Permit Number: 091163

has permission to Build new Single Family Home 3.5 bedrooms, 3.5 baths, & 2 car detached garage

AT 119 NOYES ST

**From:** Philip DiPierro  
**To:** Code Enforcement & Inspections  
**Date:** 12/1/2009 9:05:27 AM  
**Subject:** 119 Noyes Street, Single Family Site Plan Review

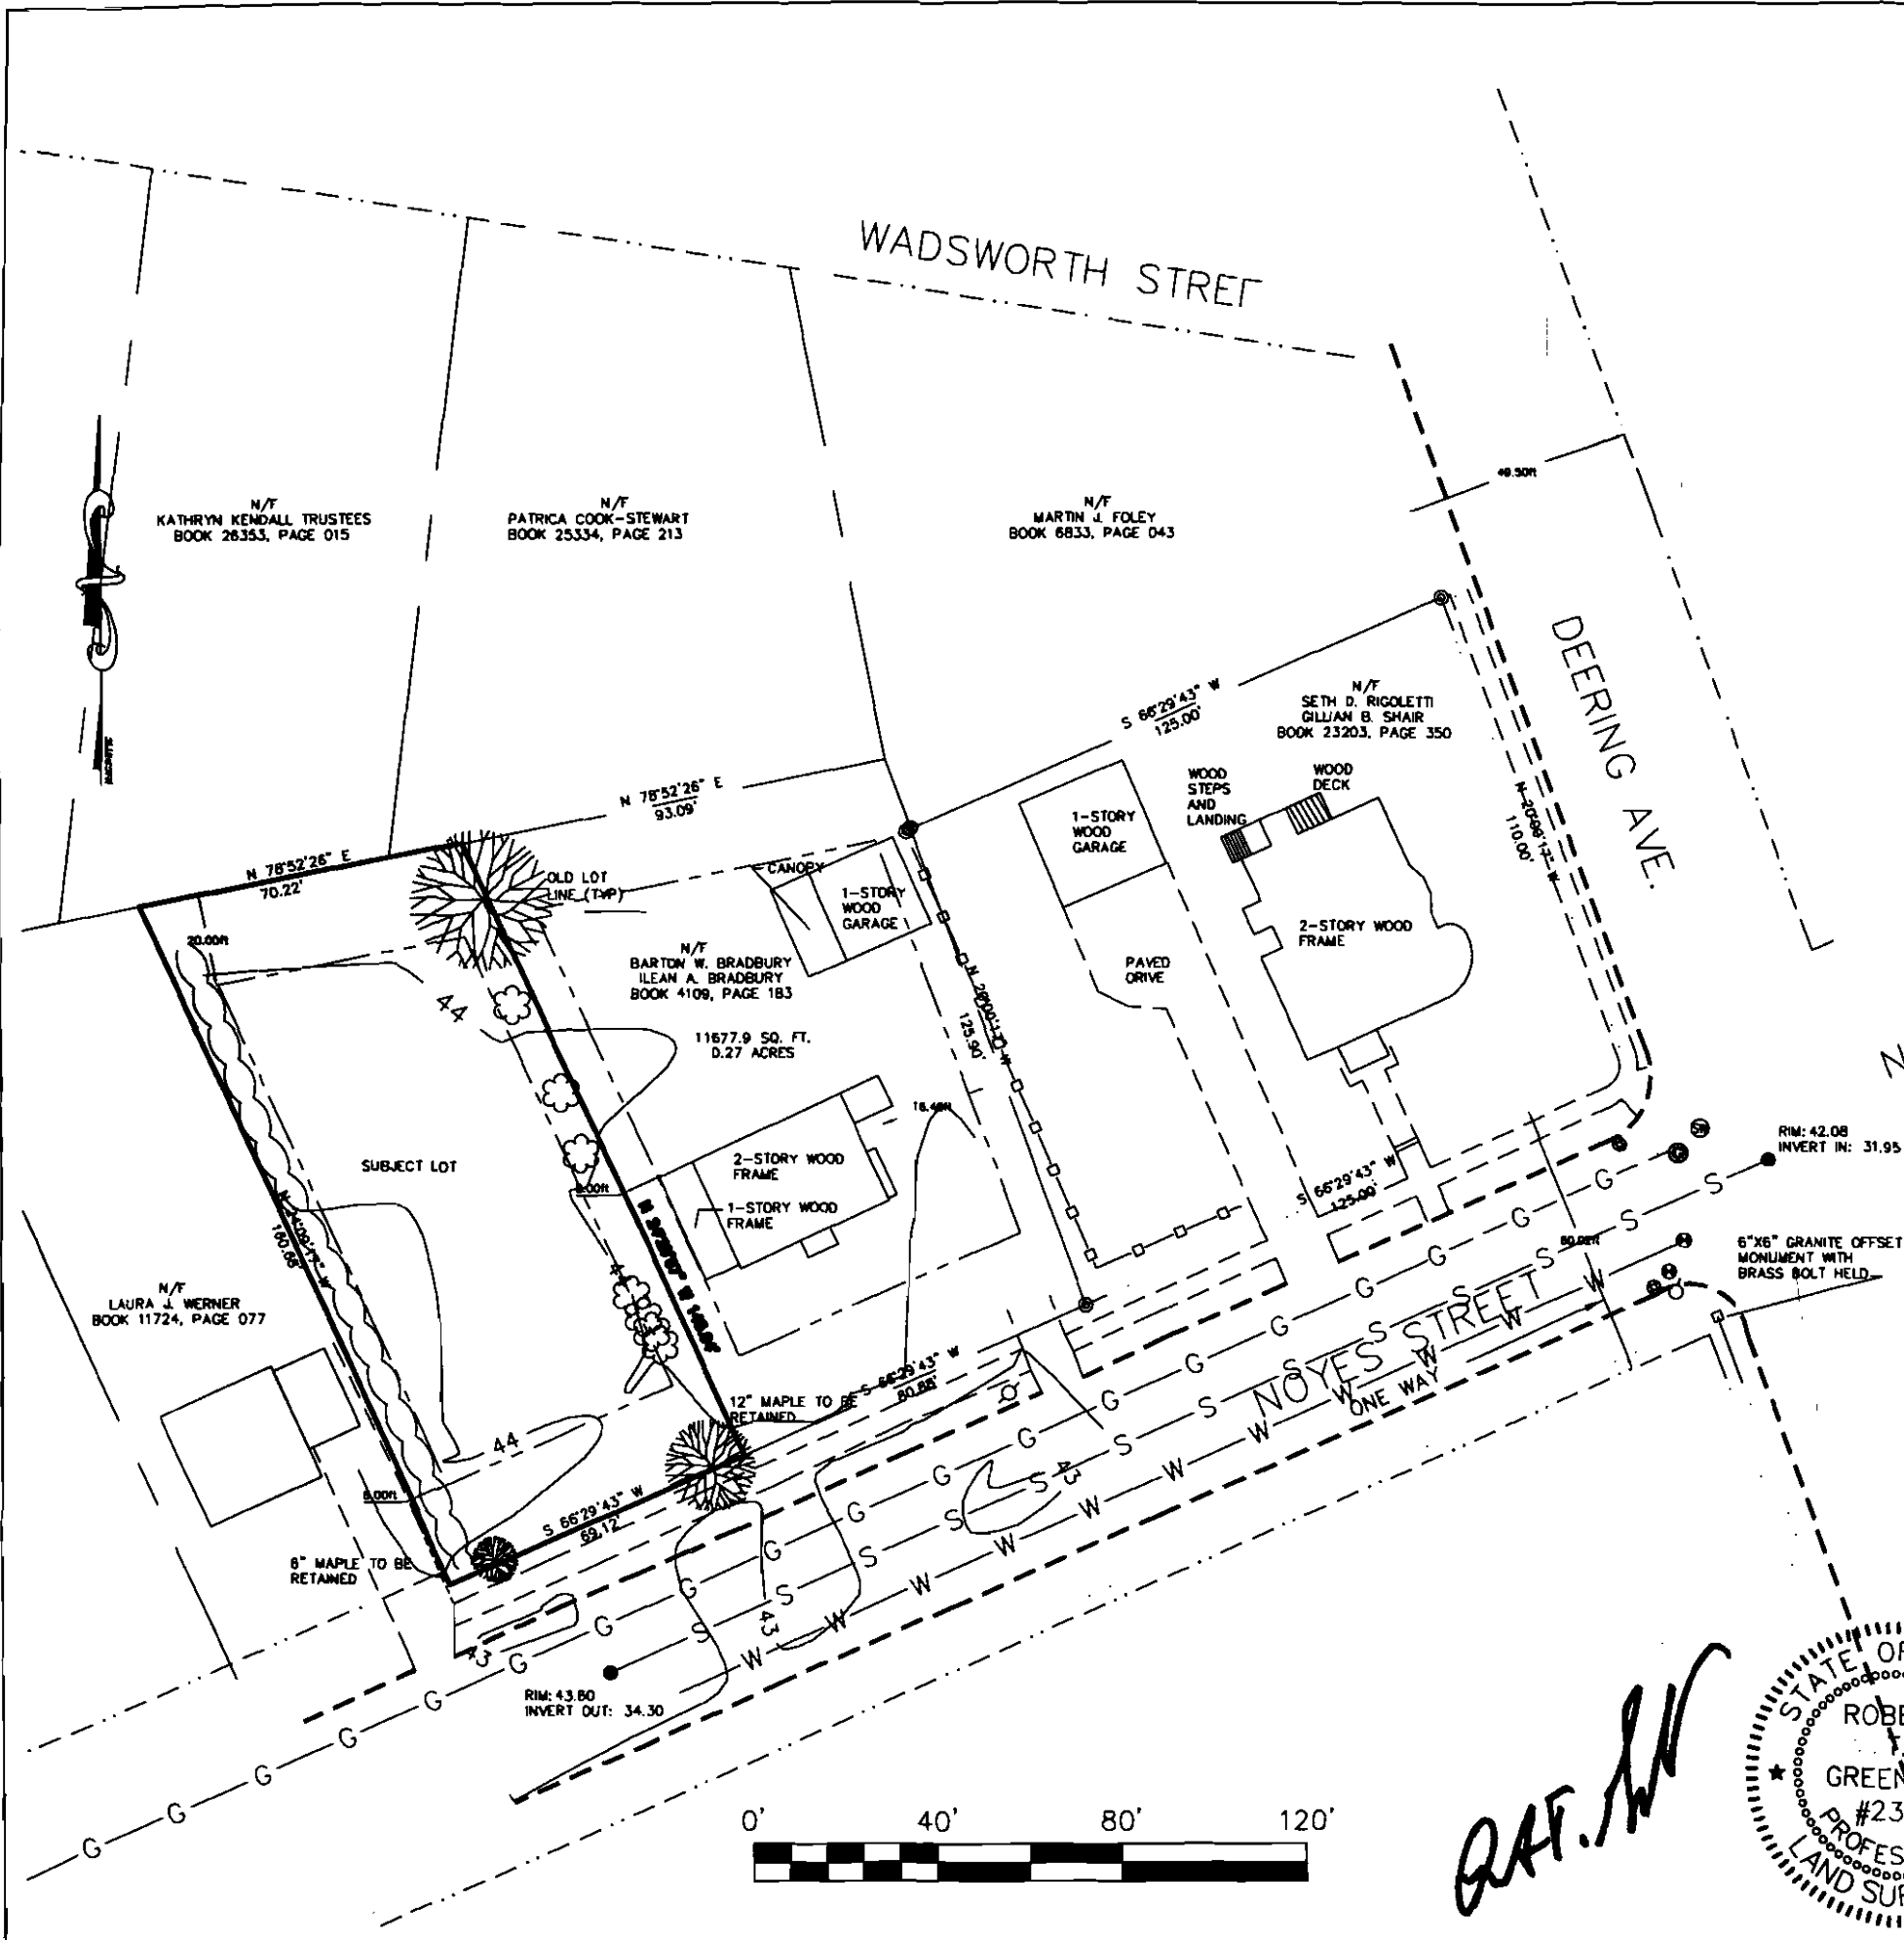
10/23/2009-amachado: Finished review. Dimensions of footprint on siteplan don't match the dimensions on the building plans. Need to wait for Phil to finish his review before we contact Jonathan Culley.

11/2/2009-amachado: Phil is set with his review. Called Jonathan Culley and let him know that the dimensions on the building plans did not match the dimensions on the site plan. Moving permit forward to inspections for their review, but can't sign off until I receive the revised siteplan.

11/10/2009-amachado: Received revised siteplan from Jonathan Culley.

11/30/2009-amachado: Received revised site plan. Revisions did not change any of the zoning. It is still all set.
